A38 Derby Junctions
TR010022
8.x Statement of Common Ground with
McDonald's

**A38 Derby Junctions
Development Consent Order 202[]**

**Statement of Common Ground
McDonald's**

Drawing Title  
FIGURE 2.6  
MARKEATON JUNCTION  
GENERAL ARRANGEMENT

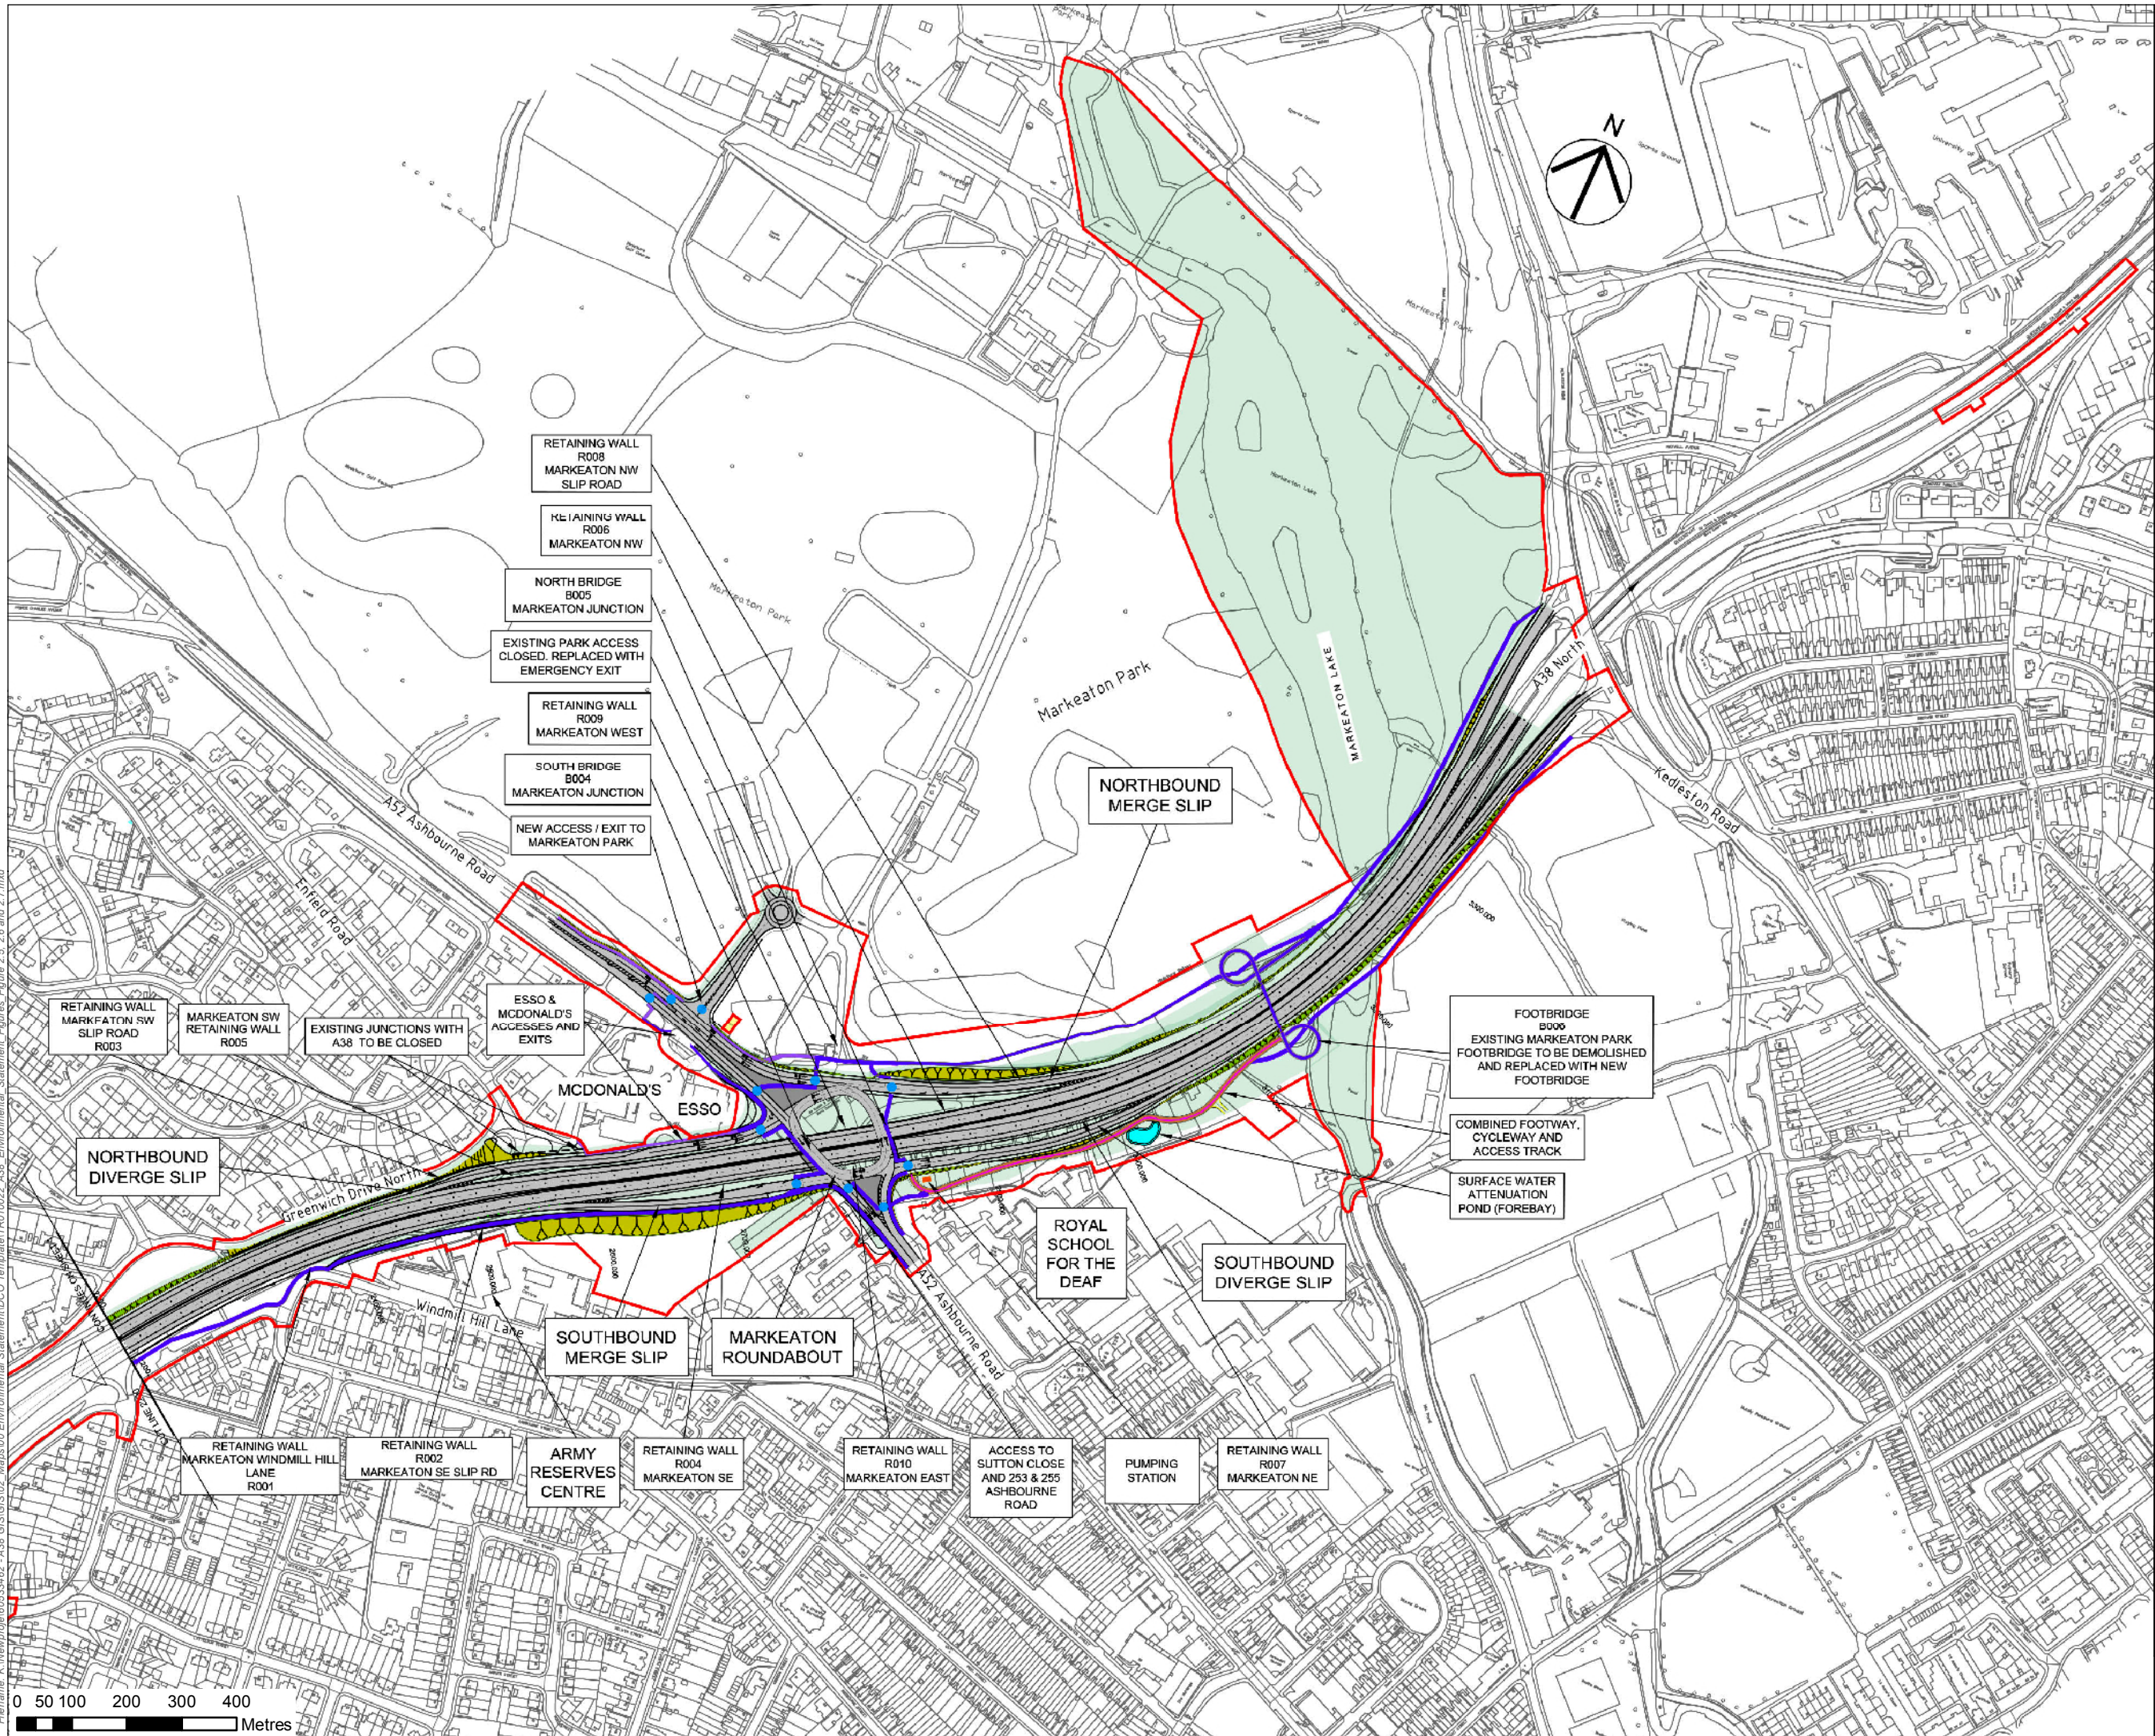
Issues Reference (see Appendix A)	Document	Paragraph Ref	Sub-section	Comment	Highways England Response	Status
Issues ref: I.1, access and economic impact	Written Representation Comments*	Point 1	a)	The Works involve closing the entrance to the Property from the A38. This would cause increased queuing at the Ashbourne Road entrance and exit to the Property, posing a health and safety risk to road users, as well as negatively impacting McDonald's business, brand, sales, operations and the amenity of the local area for residents (in each case during and after the works). Additionally, the increased capacity at the Ashbourne Road junction will go beyond its capability.	<p>Exiting the site onto the A38 will continue to be an option after implementation of the scheme. Entry to the site from the A52 will be via a new signal-controlled junction so will not cause queuing within the site.</p> <p>This is a contradictory statement and not agreed. The signals will cause vehicles to wait, i.e. queue at the stopline.</p> <p>Despite its contradictory nature, the above response does not fully respond to our concern. Our concern is the health and safety and impact on McDonald's as a result of the proposed closure of the A38 entrance.</p>	Under discussion

Issue ref: I.1, access and safety	Written Representation Comments*	Point 1	b)	The proposed installation of traffic lights at the Ashbourne Road junction will cause gridlock and queuing inside the McDonald's site, especially	The proposed exit onto the A38 slip road will be able to perform better than the existing exit due to the greatly reduced flow passing the exit on the A38 slip	Under discussion

Issues Reference (see Appendix A)	Document	Paragraph Ref	Sub-section	Comment	Highways England Response	Status
Issue ref: I.1, access and potential impacts	Written Representation Comments*	Point 2	a)	<p>Currently, deliveries to the Property are received five times per week from the A38 entrance. The Works necessitate a change in delivery routes into the restaurant. The proposed route does not account for how McDonald's delivery vehicles manoeuvre around the Property or potential health and safety concerns. Delivery cages weigh hundreds of kilograms and McDonald's' car park is reinforced in the south part only. By closing the A38 entrance, delivery vehicles will no longer be able to service the Property; they are too heavy to safely cross the unreinforced north section of the Property.</p>	<p>Swept path diagrams have been provided to demonstrate that access for deliveries from the proposed new A52 access is feasible within the current car park layout (and crossing onto the Euro Garages land as they do at present).</p> <p>McDonald's does not have generic rights to encroach on the Euro Garages site. Unless the new delivery route crosses the Euro Garages land in the same place and manner as the existing delivery route, in the absence of a formal arrangement with Euro Garages, McDonald's may not have the necessary rights and will be at risk of a third party preventing deliveries to (and refuse collection from) the restaurant, which would leave it unviable.</p>	Under discussion

Issue Reference (see Appendix A)	Document	Paragraph Ref	Sub-section	Comment	Highways England Response	Status
Issue ref: I.1, potential impacts	Written Representation Comments*	Point 3	a)	It appears as though the Works at the junction between the Property and Ashbourne Road encroach onto the Property.	<p>Highways England does not believe that the proposed layout encroaches onto land owned by McDonald's. However, it may be necessary to install some items (such as signal detector loops) within land owned by McDonald's so an agreement relating to future maintenance of such items will need to be reached.</p> <p>HE are proposing that queuing traffic up to the stop line is on McDonald's land. It may be possible that detector loops or similar equipment are required on McDonald's land. This is not standard practice and no detail of maintenance, liability or consideration of McDonald's private plant has been provided</p>	Under discussion

Issues Reference (see Appendix A)	Document	Paragraph Ref	Sub-section	Comment	Highways England Response	Status
				around the access and egress to the Drive-Thru lanes.	<p>road. The proposed exit on the A52 will be able to perform better than the existing exit due to the introduction of traffic signals.</p> <p>The TRANSYT model does not provide sufficient information to accurately assess the local impact on the proposed junction serving the site. Within the 90 second cycle time, McDonald's (and PFS traffic) will only have 2x 7 seconds of green time in every 90 second cycle to exit.</p> <p>As referred to above, the signals will cause vehicles to wait at the stopline; this will cause congestion in the site where currently cars can exit with limited or manageable queuing.</p>	
Issue ref: I.1, assessment of impacts	Written Representation Comments*	Point 1	c)	The site traffic survey undertaken in 2015/16, which formed the assessment of the Works, is outdated and guest numbers to the Property have	A Technical Note covering this and point 1a and 1b above has been prepared by Highways England's designers and this will be shared with McDonald's with	Under discussion

Issues Reference (see Appendix A)	Document	Paragraph Ref	Sub-section	Comment	Highways England Response	Status
					<p>Highways England has advised that, during the detailed design stage, pavement surveys could be carried out to determine the strength of all parts of the car park – strengthening could be carried out as accommodation works if required.</p> <p>No description is provided of how the car park could be strengthened, or how business would be maintained at the restaurant while these works were undertaken.</p>	
Issue ref: I.1, access and safety	Written Representation Comments*	Point 2	b)	Servicing via Enfield Road (if this remains open) is not appropriate since it is unsafe for heavy trolleys to pass across a non-flat route. There are also practical concerns relating to the safe operation of large commercial vehicles.	<p>It will not be necessary to consider routing deliveries via Enfield road if the above proposals are accepted.</p> <p>The above proposals introduce a greater amount of HGV manoeuvres within the McDonald's customer car park, including greater risk of a delivery being affected by a</p>	Under discussion
